## **Objection to proposed Metal Recovery and Recycling Facility (SSD 8375) 56-69 Tattersall Road, Kings Park**

This letter is our formal objection to the State Significant Development (SSD) Application for the metal recovery and recycling facility (SSD 8375) (the Proposal) at the 'Pick and Payless' site, 56-69 Tattersall Road, Kings Park (the P&P site). This letter has been prepared based upon our review of the documentation (Environmental Impact Statement (EIS) and associated technical reporting and plans) placed on public exhibition for SSD 8375.

This submission is made on behalf of Sell and Parker whom own and operate a number of properties on Tattersall Road, Kings Park. In particular, Sell and Parker own and operate the neighbouring metal recovery, processing and recycling facility at 45/23-43 Tattersall Road, Kings Park (the Sell and Parker site). This site is located immediately west of the P&P site.

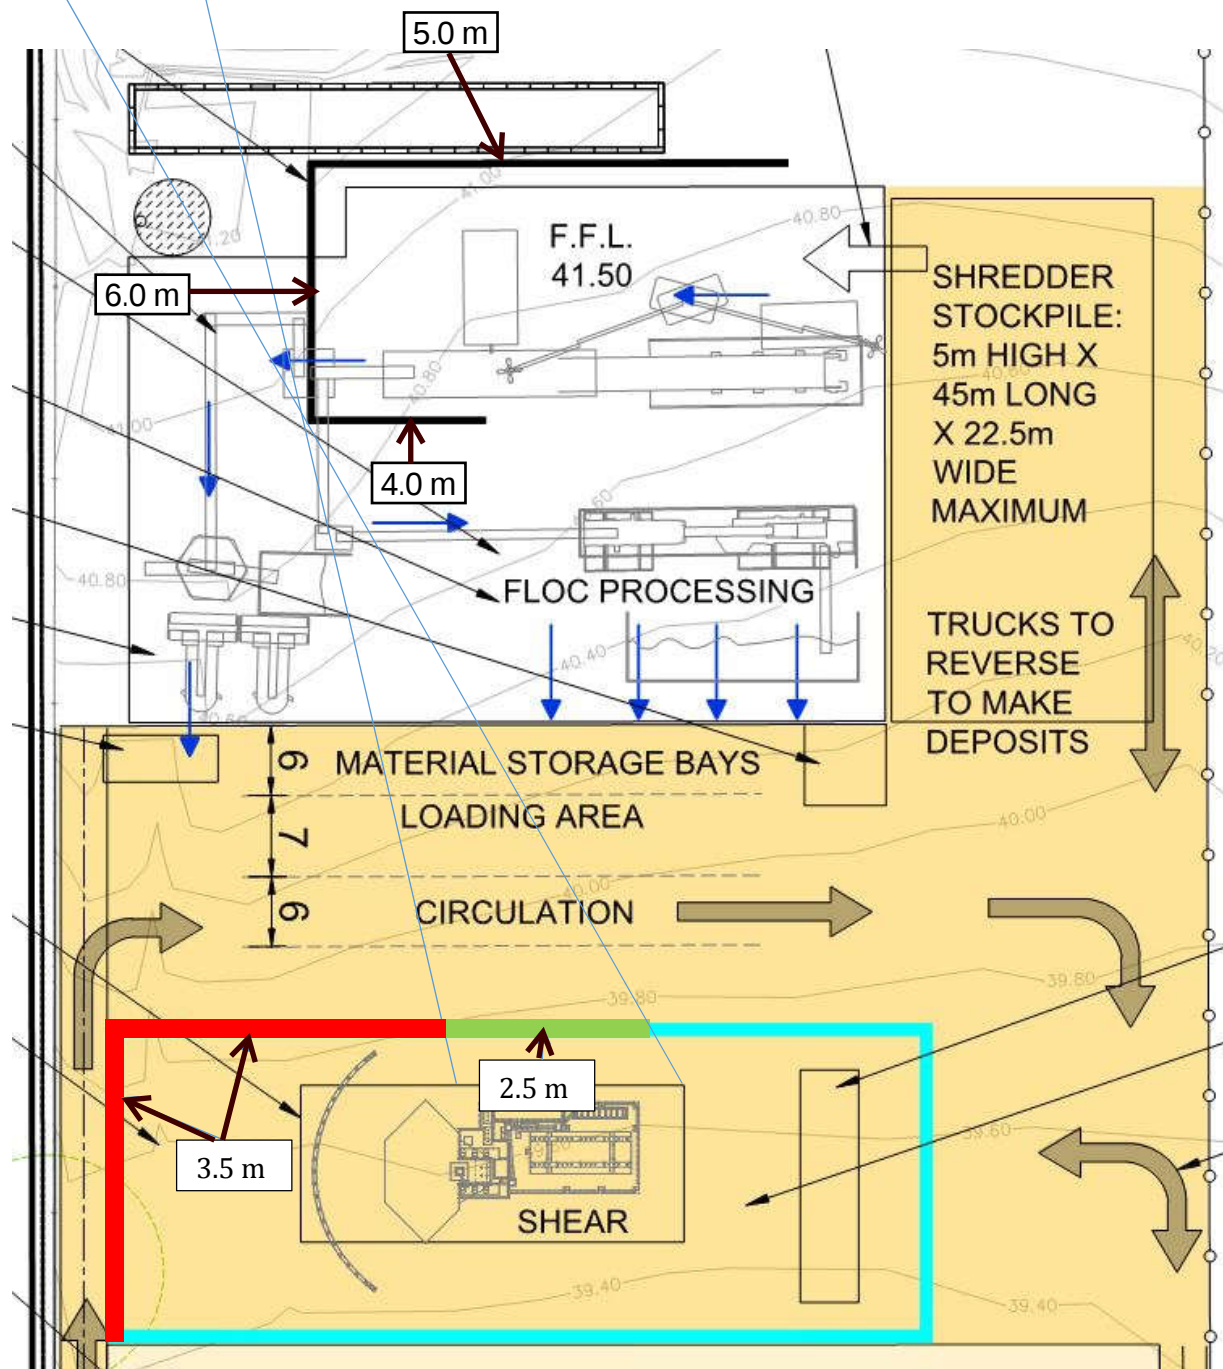
<p>The Development Plan (Appendix A of the EIS) is considered only indicative and in addition to being inconsistent with the Development Description (discussed below) is not considered of suitable detail for assessment. In particular, built form (such as sheds etc) has been proposed with no elevations and sections provided. This level of detail is required by Schedule 1 of the <i>Environmental Planning and Assessment Regulations 2000</i> (EP&amp;A Reg) and is requested in the SEARs.</p> <p>It is noted that Engineering Plans (Appendix S of the EIS) have been provided however these lack a distinct identification of final surface levels and, in particular, the location of sections provided have not been shown on the plans for reference.</p>	Appendix A and Appendix S	The Development Plan and Engineering Plans should be updated to include further detail, particularly elevations and sections.

Figure 4 – ‘Proposed site layout’ includes a plan (revision E) which is inconsistent with the Development Plan (revision H) provided within Appendix A. Of particular note is inconsistencies with stockpile sizing and locations and the proposed western driveway not being shown in the Development Description.	Section 4 and Appendix A	The Development Description should be updated to be consistent with the Development Plan.
		Section 4.3.3 identifies that four car parking spaces are to be removed from the existing visitor parking area (to the immediate south of Building A) however this is not identified on the Development Plan.	Section 4.3.3 and Appendix A	The Development Plan should be updated to indicate the car parking spaces which are to be removed (within the visitor parking area) as part of the Proposal.
		Section 4.5.2 indicates types of input material which cannot be shredded by the Thor 2121K shredder. The method for managing (stockpiling, processing and/or transporting off-site) is not clearly identified.	Section 4.5.2	The Development Description should be updated to include a description of how

Section 4.5.8 indicates that 10 x 900L tanks would be used for fuel, oil, diesel and coolant storage. Notwithstanding this, the Development Plan indicates that 10 x 980L tanks would be provided for this storage. Therefore, there seems to be a discrepancy of 800L storage potentially of fuel on-site which could impact upon the impact assessment (fire and general hazard and risk) undertaken within the EIS.	Section 4.5.8	Ensure that that Development Plan and Development Description identify a consistent amount of storage of fuel (or other products) on the P&P site. Further impact assessment should be

No.	Issue	Comment	EIS Reference	Initial recommendation
				undertaken as appropriate.
		Section 4.7.3 indicates that a 'dust suppression system' would be installed for the Proposal. This implies that an emissions control system is to be installed for the Proposal, however no further details in regards to the location of this system, the specific operation of this system or how it would be monitored have been provided. Further information would improve the impact assessment provided.	Section 4.7.3	The Development Description should provide further details in relation the location and functionality of the proposed dust suppression system.
		The Development Plan identifies a number of stockpiles which are to be located adjacent to the proposed operational equipment. Overall the location and extent of stockpiles is not considered consistent with the processing (quantum or operational requirements for feeding materials into the equipment) to be undertaken on the P&P site. In particular, the 'shredder stockpile' identified is not in close enough proximity to the shredder to feed this equipment. It is therefore considered likely that the 'shredder stockpile' represents a preshredder stockpile with another stockpile/s being required for the shredder. The location of stockpile is important to ensure an adequate impact assessment (land and water contamination, noise, air and fire management) can be undertaken.	Appendix A	A detailed stockpile plan should be provided to show specific locations (and sizing) for all stockpiles proposed on the P&P site.
